From: Juan Baeza
Sent: 18 January 2018 15:25
To: Planning.Responses
Cc: Amanda Scholes
Subject: WA/78/17/DOC

Subject: RE: Walberton

Project: Red Cottage, West Sussex
Drawing No.: 536/501
Drawing Title: Typical Soakaway Section A-A
By: JD
Date: November 17

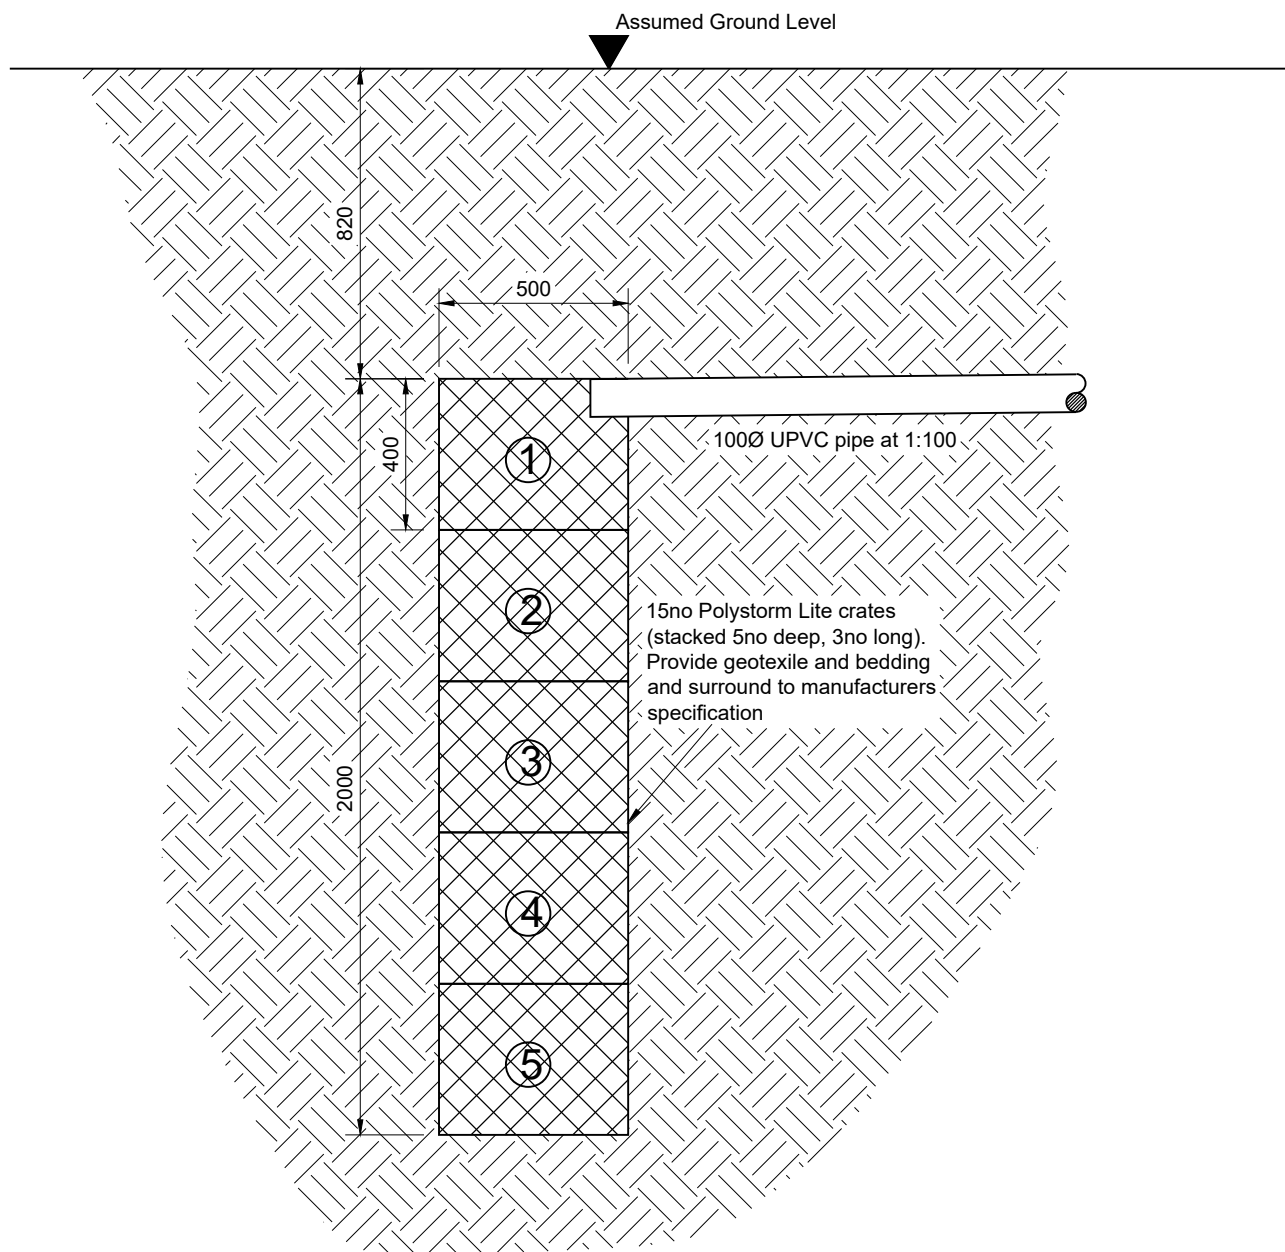
1. Please provide all the readings associated with the 13 minute percolation test ie. water level readings from 0 mins to 13mins, so the rate can be checked.
2. The storage calcs show a minimum soakaway depth of 1.944m being required. How can this be achieved based upon the design requirements. ie. soakaway base must not extend more than 2m below ground level and you also need to achieve adequate cover to the crates for protection.
3. Please show manhole cover/invert levels, including pipe invert at connection to soakaway.
4. Specify base level of soakaway ie. a level max. 2m below ground level.
5. Provide construction detail/section of soakaway (to include permeable geotextile wrapping).
6. Manhole SW4 is to be a catchpit (provide construction detail).
7. How is the driveway being drained? Provide full details/calculations.

| Drawing Title: | Site Plan Showing Below Ground Surface Water Drainage |

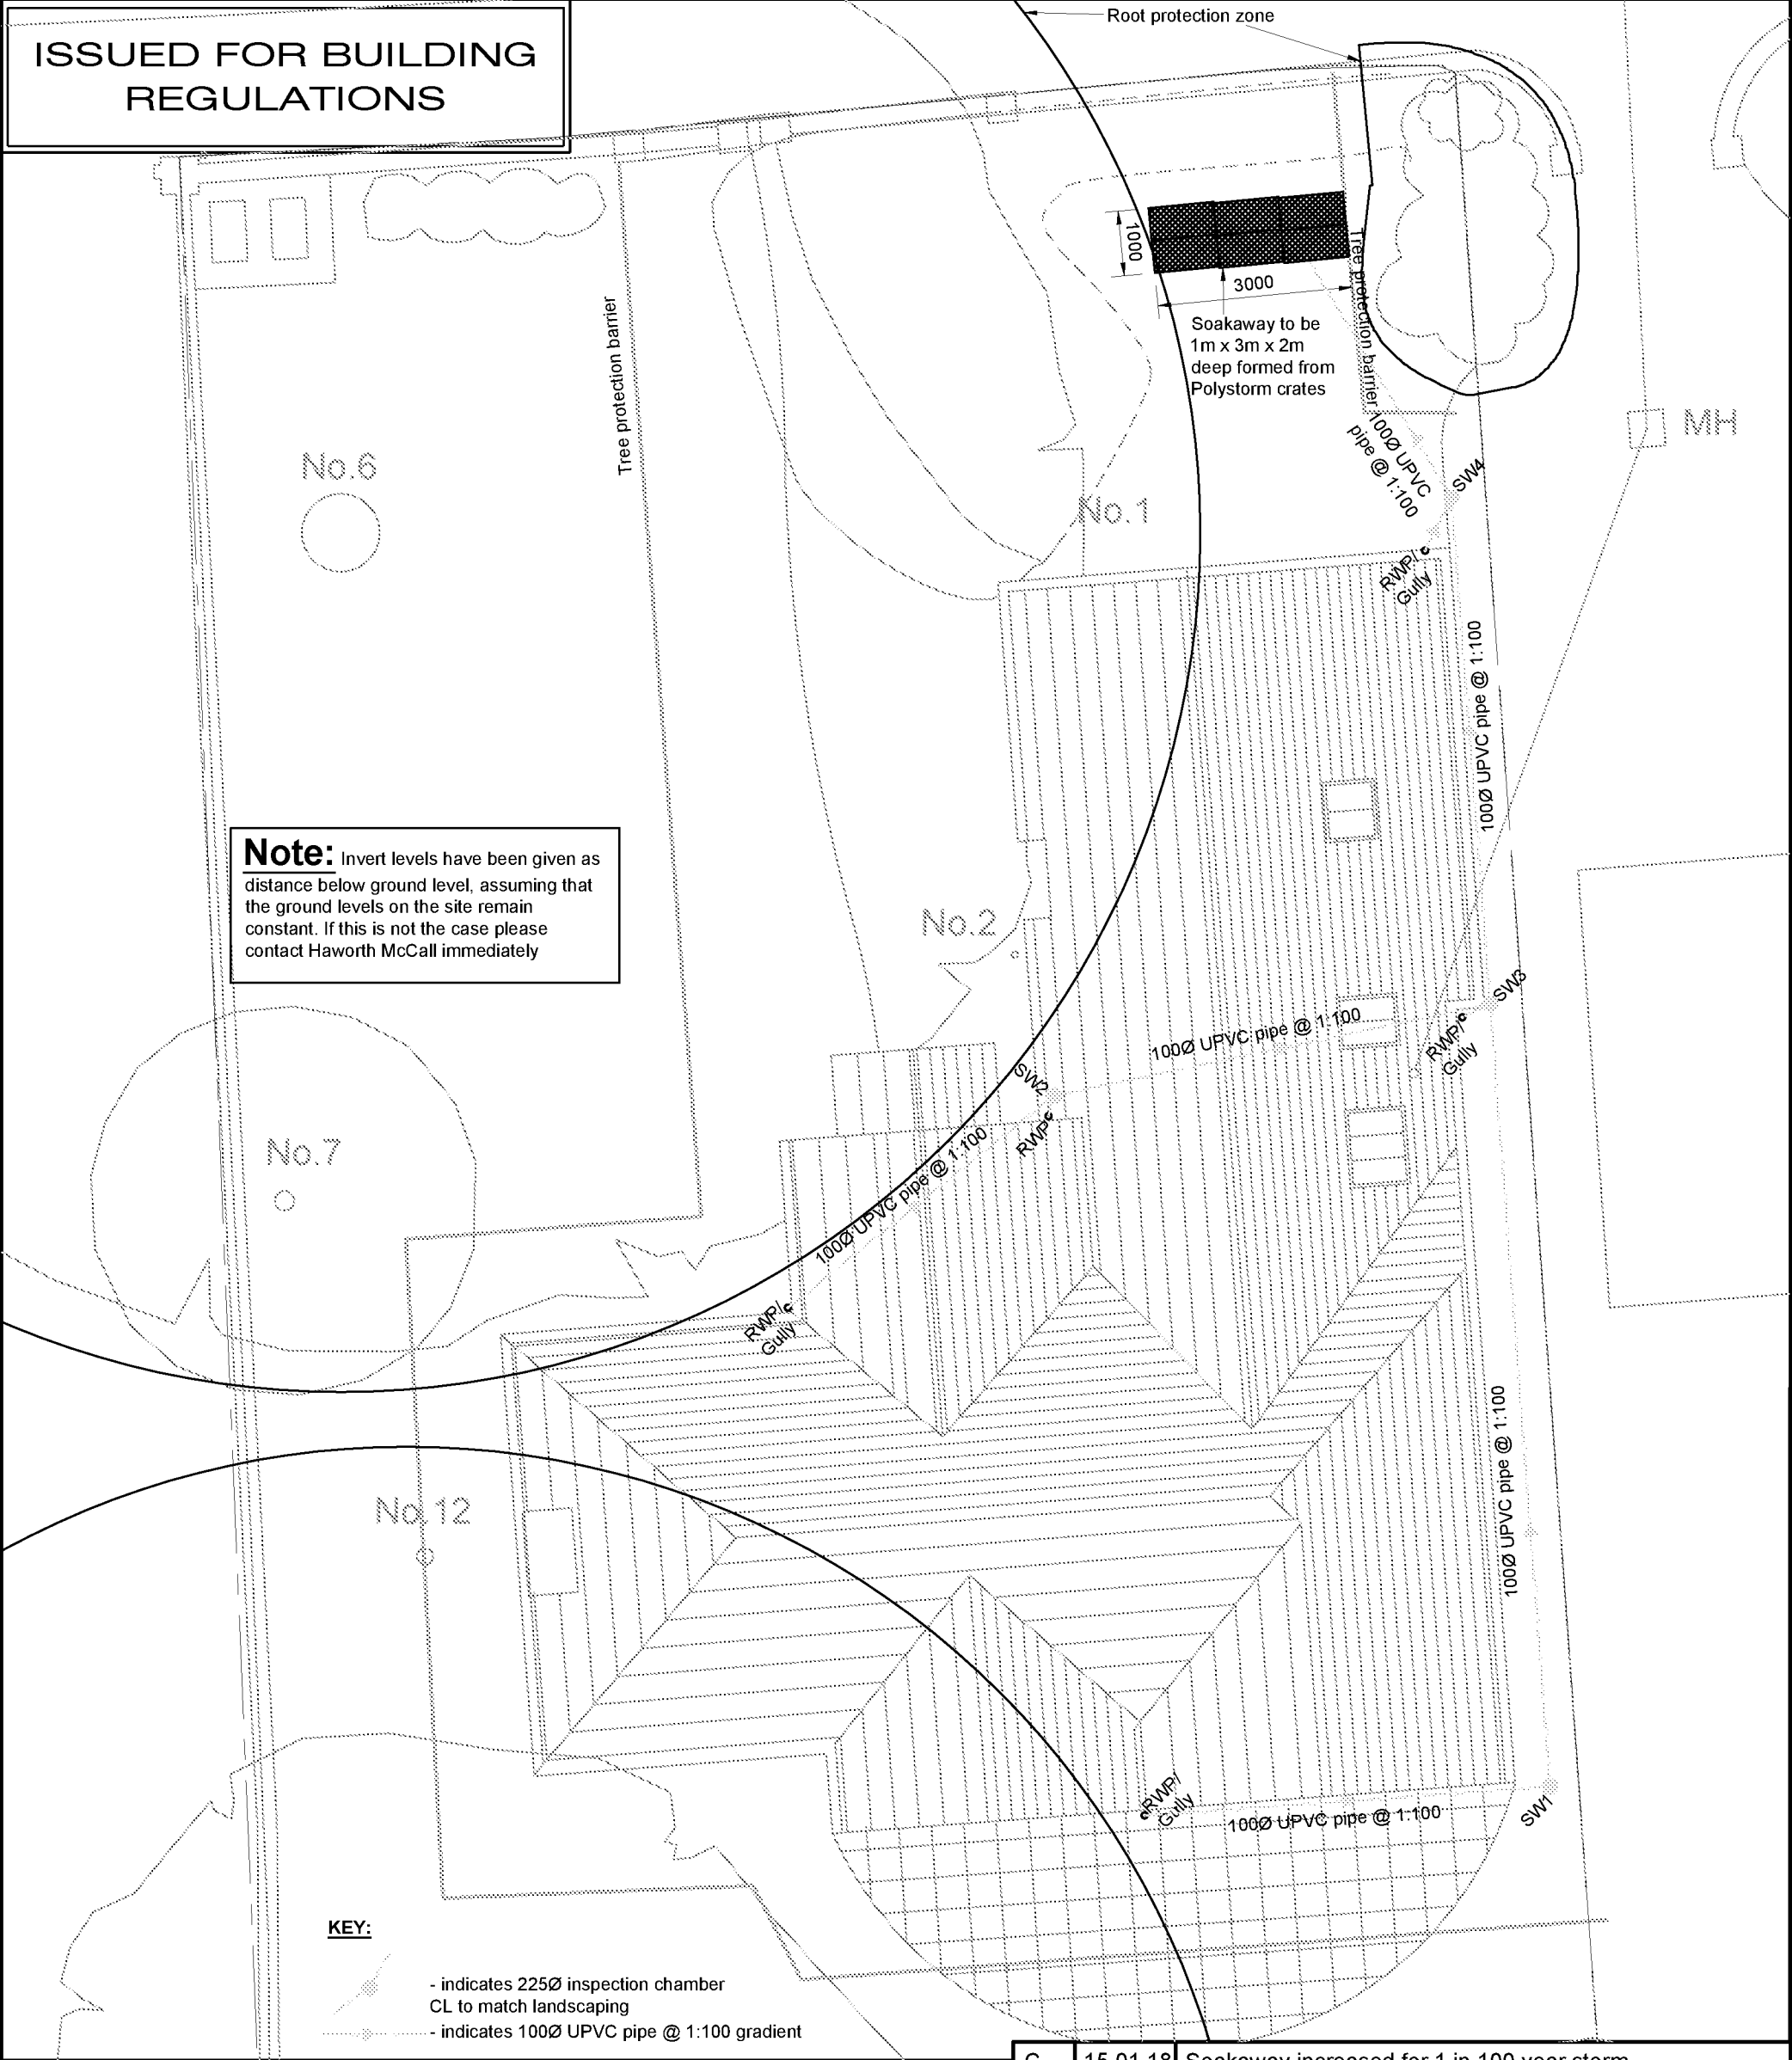
I look forward to receiving your design drawings (layout and construction details). Please note that the depth from ground level to the base of the soakaway must not exceed the depth of your trial hole.

Obviously the proposed formation level for the soakaways should not extend any deeper than your trial holes.

On point 7 of your e-mail, it has been confirmed by the applicant that all the hard landscaping areas will be permeable and therefore will not contribute to the soakaway calculation.

Attached is our amended drawing and soakaway calculation show the soakaway size and position using the infiltration test results above.
